**DGRs for the St Vincent's and Mater Health Sydney Darlinghurst Campus Master Plan  
and Stage 1 Works (SSD 5384-2012)**

<b>Application Number</b>	SSD 5384-2012
<b>Proposal Name</b>	Darlinghurst Campus Capital Master Plan and Stage 1 Works
<b>Location</b>	Victoria Street, Darlinghurst
<b>Applicant</b>	St Vincent's & Mater Health Sydney Ltd
<b>Date of Issue</b>	8 AUGUST 2012
<b>General Requirements</b>	<p>The Environmental Impact Statement (EIS) must meet the minimum form and content requirements in clauses 6 and 7 of Schedule 2 the <i>Environmental Planning and Assessment Regulation 2000</i>.</p> <p>Notwithstanding the key issues specified below, the EIS must include an environmental risk assessment to identify the potential environmental impacts associated with the development.</p> <p>Where relevant, the assessment of the key issues below, and any other significant issues identified in the risk assessment, must include:</p> <ul style="list-style-type: none"> <li>• adequate baseline data;</li> <li>• consideration of potential cumulative impacts due to other development in the vicinity; and</li> <li>• measures to avoid, minimise and if necessary, offset the predicted impacts, incl

Figure 4 – Sketch indicating extension to existing car park in front of the Aikenhead building

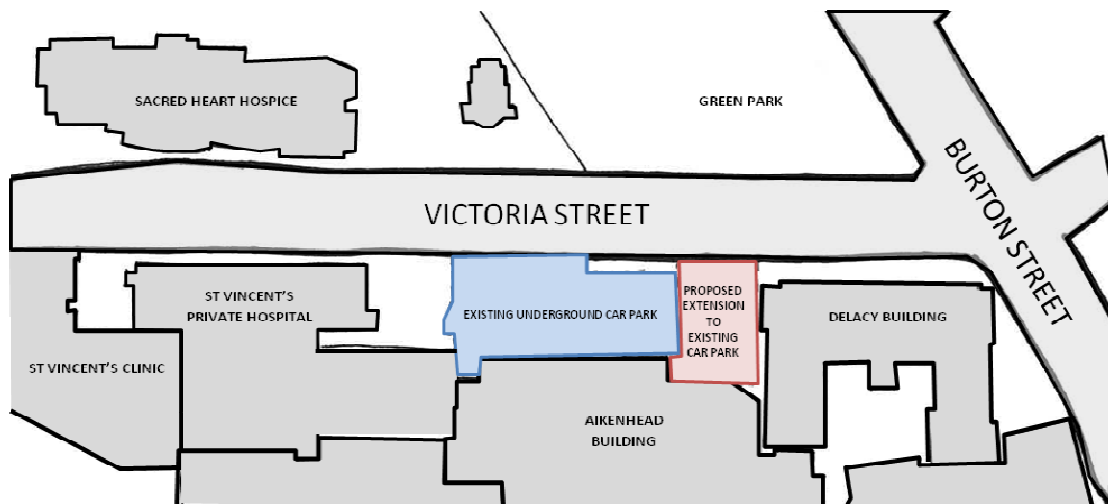
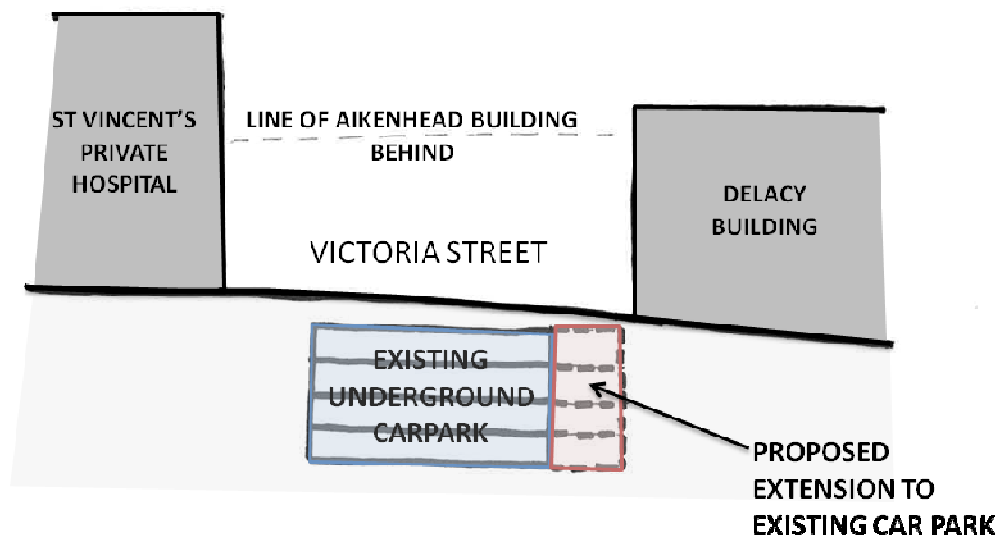
- As well as the additional 92 spaces proposed as part of Stage 1 additional parking will be provided in subsequent stages. The quantum of additional spaces, their proposed use and allocation across the campus is not specified.

- The traffic and access impacts of the Stage 1 works need to be acknowledged as a key risk. It is not indicated whether the construction of the Stage 1 - additional parking will impact on the operation of the existing car park, short stay or pedestrian access, and how these impacts will be managed. Given the constraints of the site these impacts may be significant.

- Provide detailed assessment of the current and likely future car parking demands, to provide justification for the quanta of parking proposed.
- Discuss the benefits and impacts of the proposal on public transport services within the vicinity of the site, with consideration of existing public transport arrangements, ability of the proposal to use available capacity on public transport services, and implications on public transport service planning requirements.
- Identify any construction impacts on public transport services, with information on the anticipated level of impact and proposed mitigation measures.

Figure 6 – Heritage listings (Source: Godden Mackay Logan)

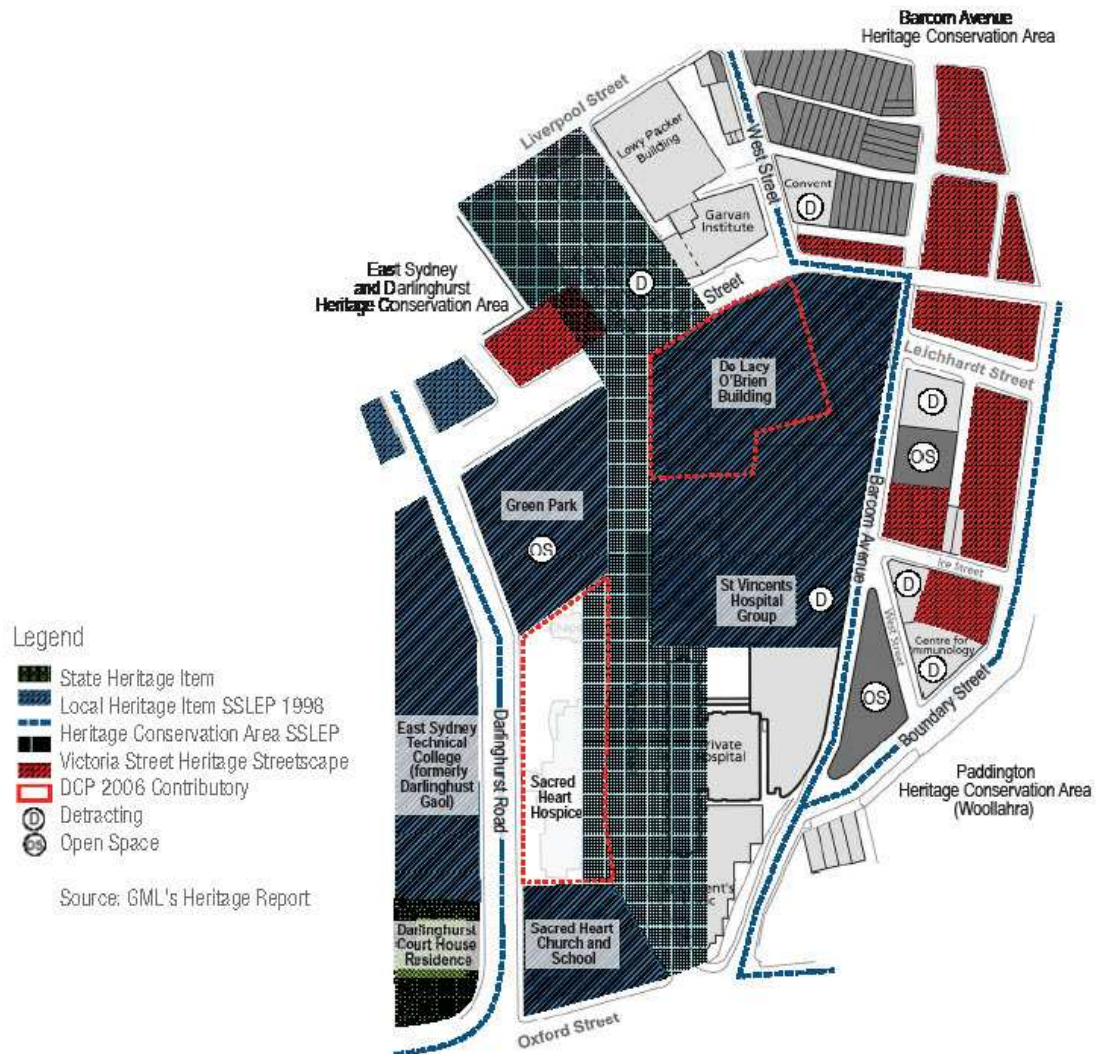
- Details regarding the retention of the heritage listed deLacy Building, along with detailed drawings showing the proposed surrounding buildings, curtilage around the item and the contextual relationship, such as how the block fits together and how the street wall height of the new buildings relate to the deLacy Building;

- How the curtilage of the chapel within the park will be preserved in view of the proposed replacement hospice building;
- Traffic issues are to be carefully detailed by suitably qualified consultants. There should be paramics microsimulation modelling of surrounding streets with anticipated traffic generation, which needs to be endorsed by RMS (incorporating background growth factors);
